(Development Charges Letter)

File No. : **CMDA/PP/NHRB/C/0235/2020**

Sub: CMDA-Area plans Unit - 'B' Channel (Central) – The Planning Permission application received for the pro construction of Stilt + 4 floors Office building at Old Door No.3, New Door No.7, Thirumurthy Nagar 6th Str Nungambakkam, Chennai comprised in R.S.No. 129/1 (as per document), R.S.No.129/3, Block No.21 (as Patta) of Nungambakkam village within the limit of Greater Chennai Corporation Remittance of DC & Oth charges – DC advice Sent - Reg

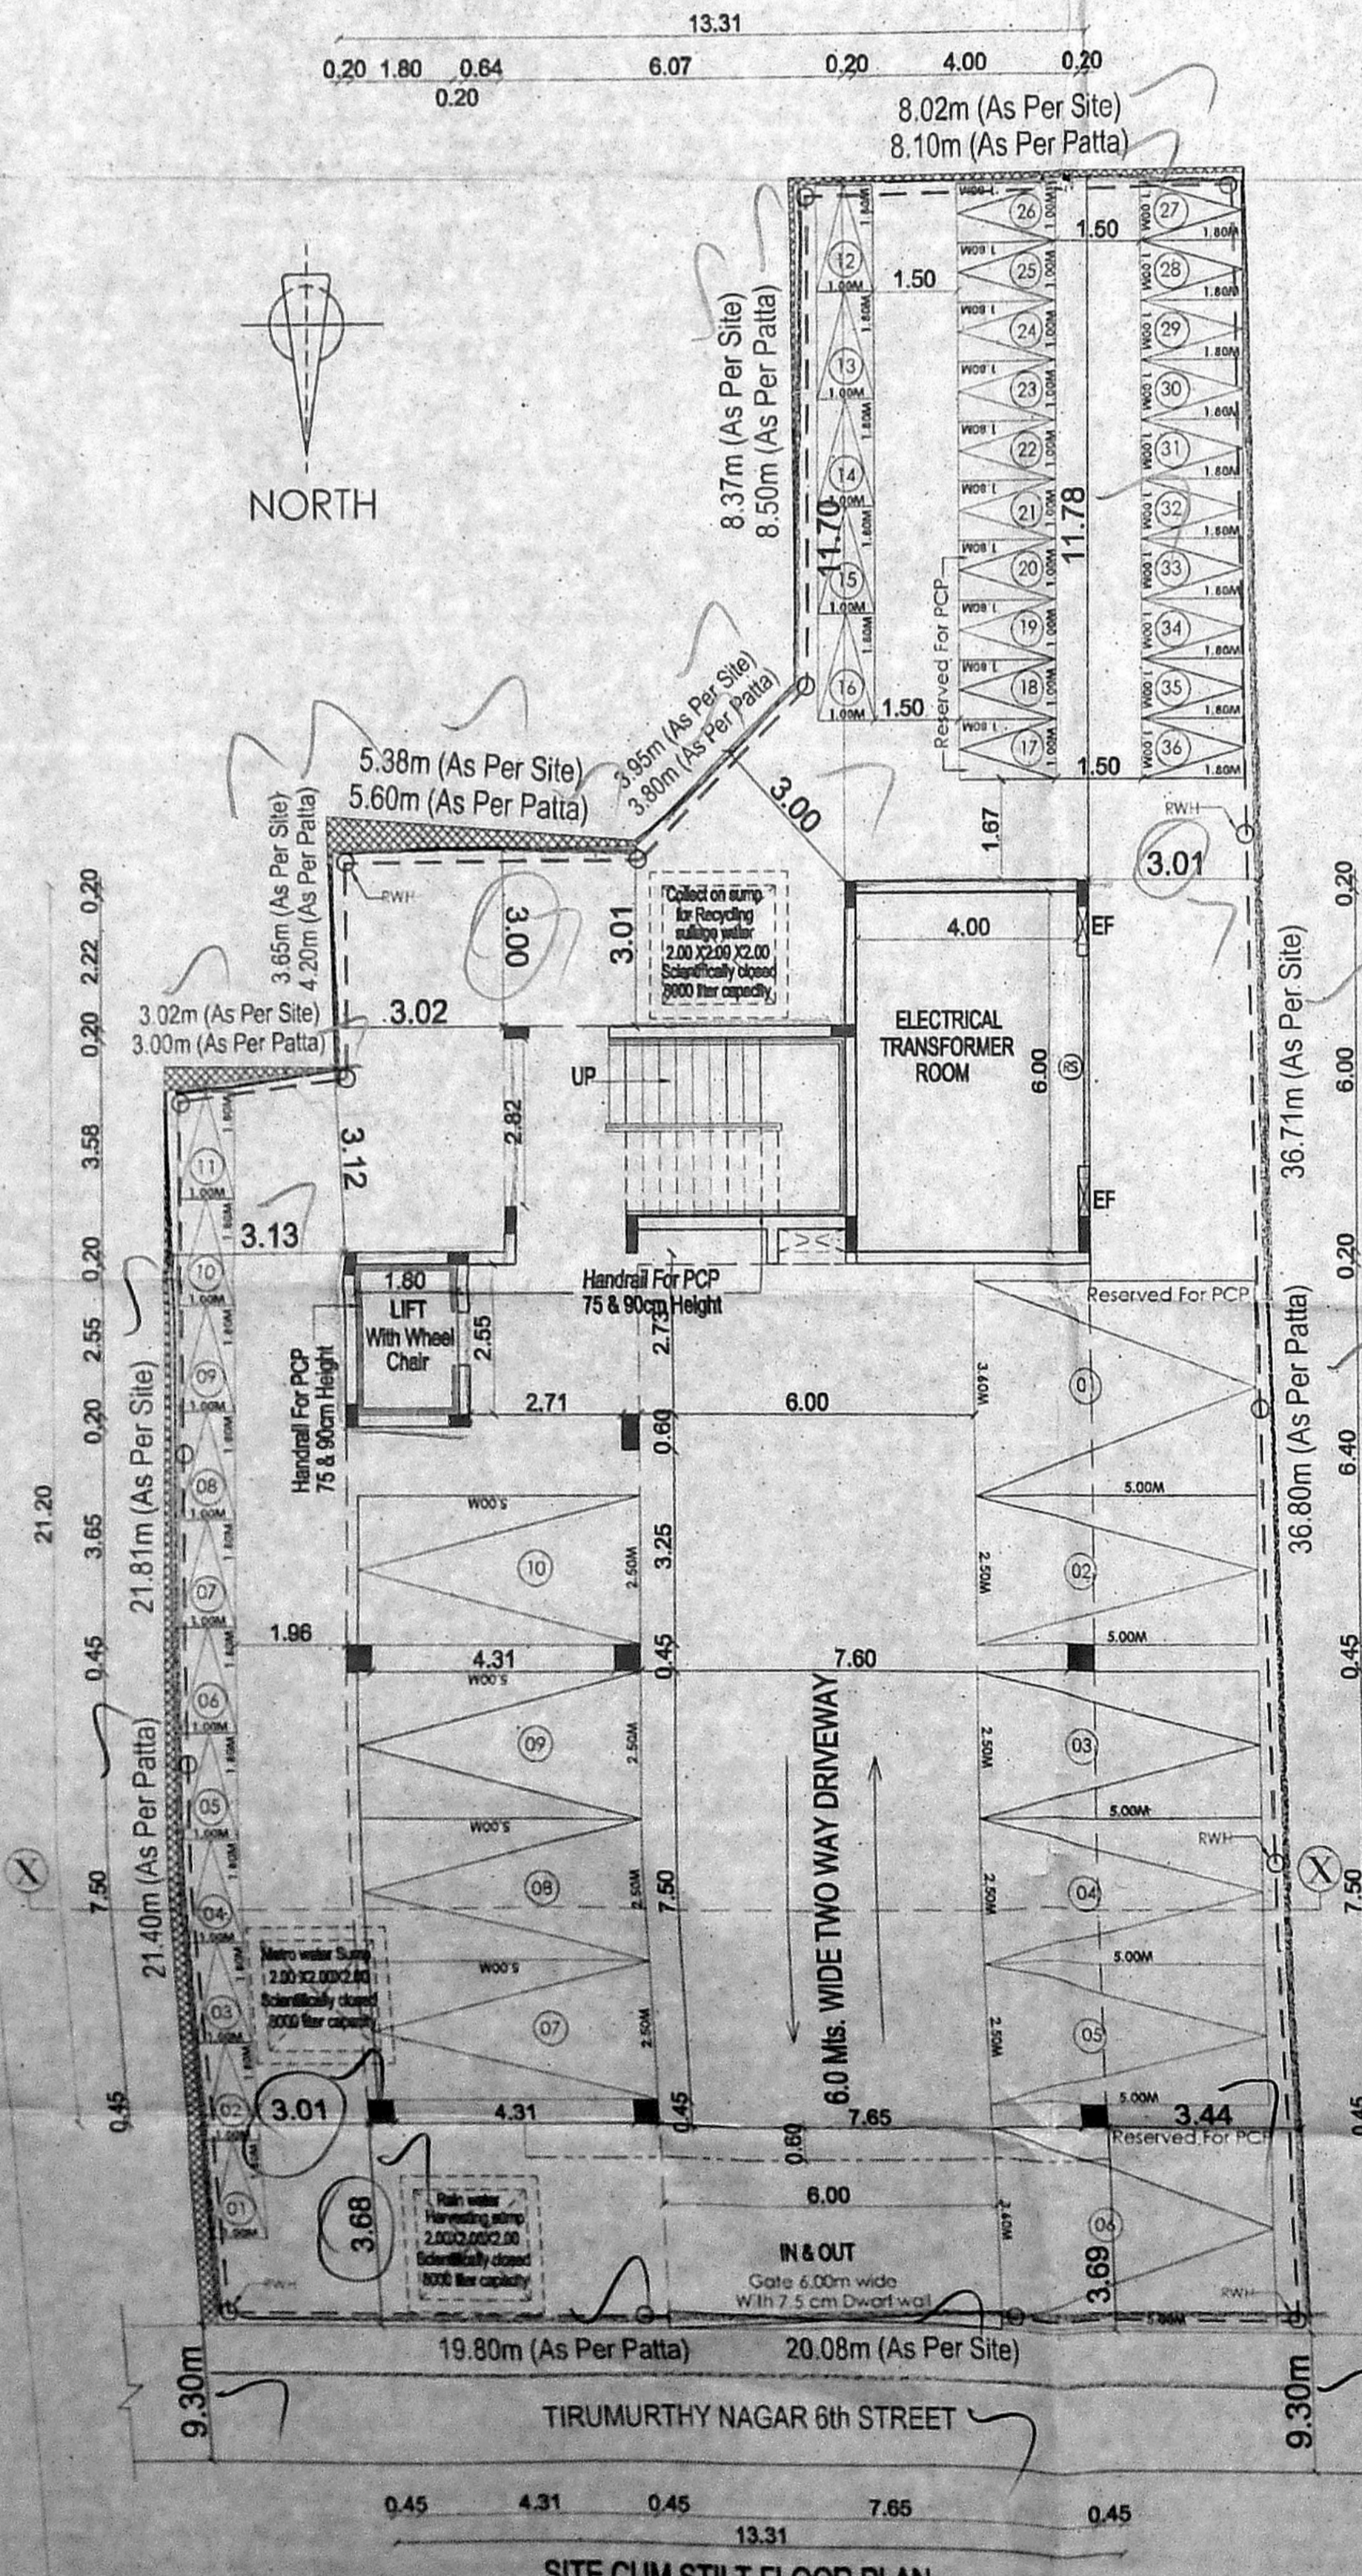
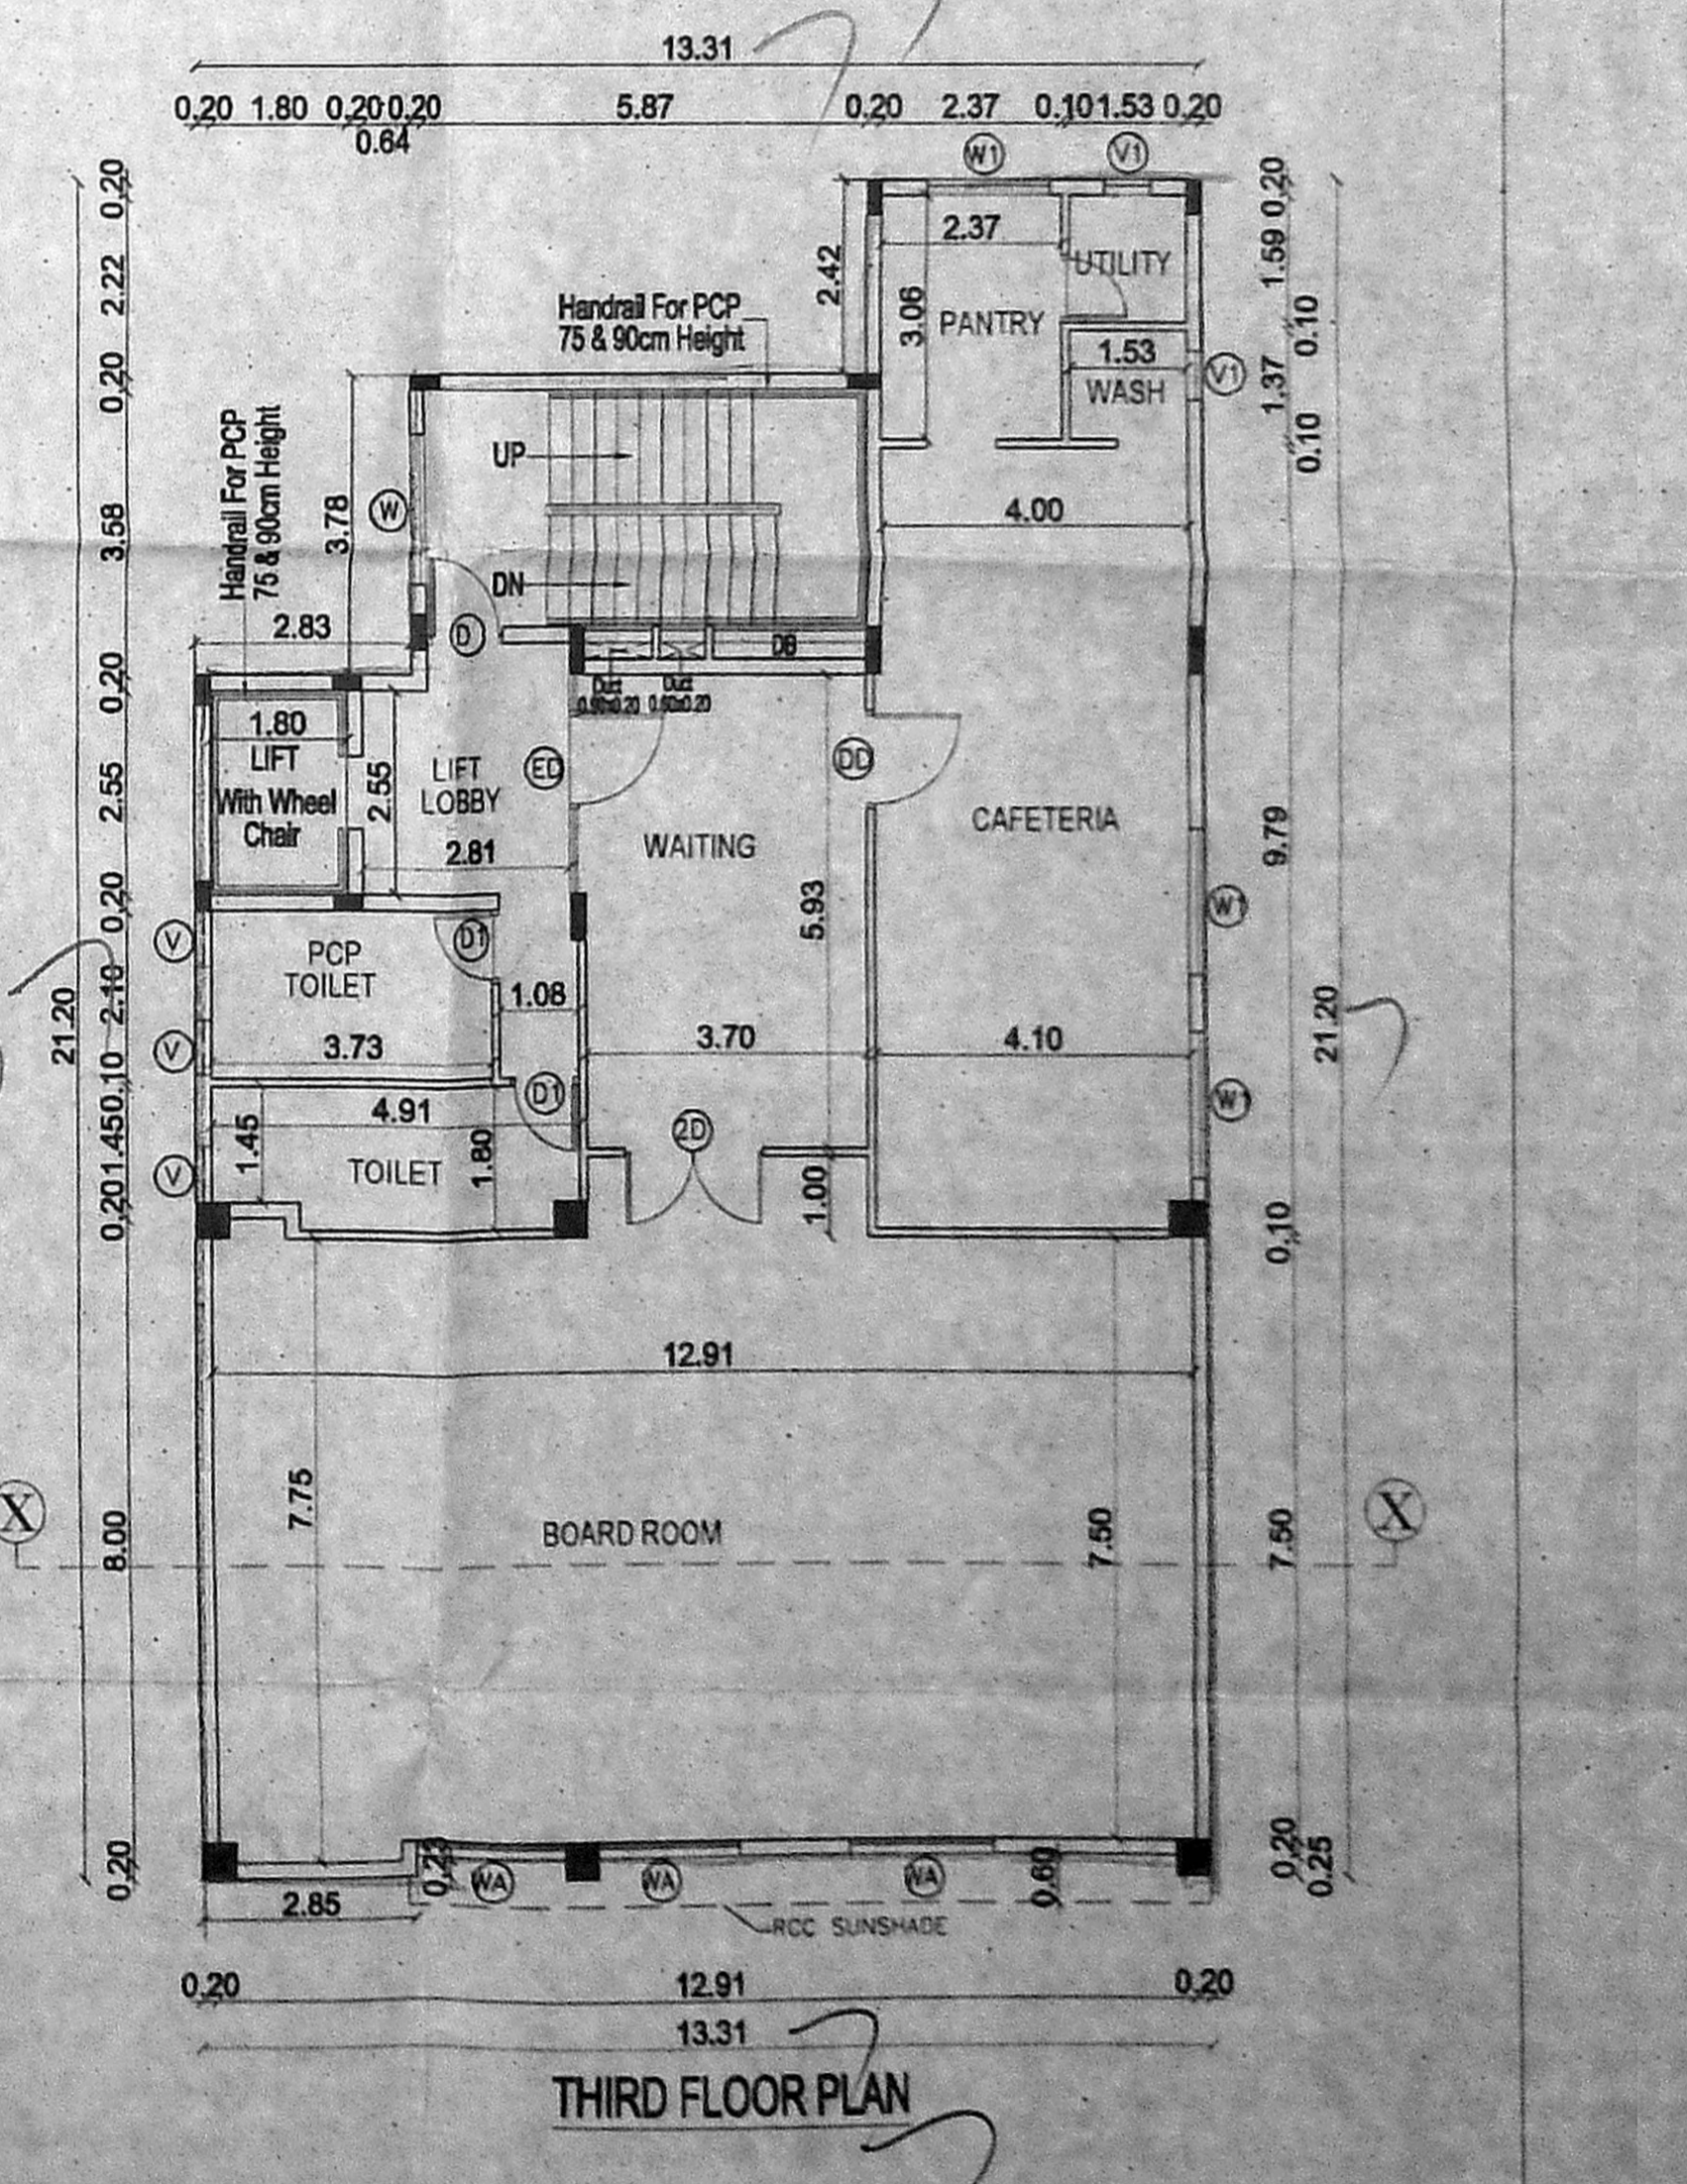
- PCP T.W. parking less by 4 nos (Required-4 nos, Provided =Nil)
- PCP toilet to be provided in 4th floor plan.
- Survey plan duly attested by Revenue officials not below the rank of deputy Tahsildar to be furnished.
- Set back dimensions are to be shown correctly.
- Area statement, Title of plan, Road width, Terrace floor plan, Section and Elevation to be shown correctly.
- Original legal opinion from Govt. Pleader for the ownership rights on Site u/r to be furnished.
- CMDA Registration copy for Developer is to be furnished.
- Form C in Rs.20/- stamp paper as per the format prescribed in TNCD& BR to be furnished.
- RCC sunshade at front set back to be shown in hidden line.
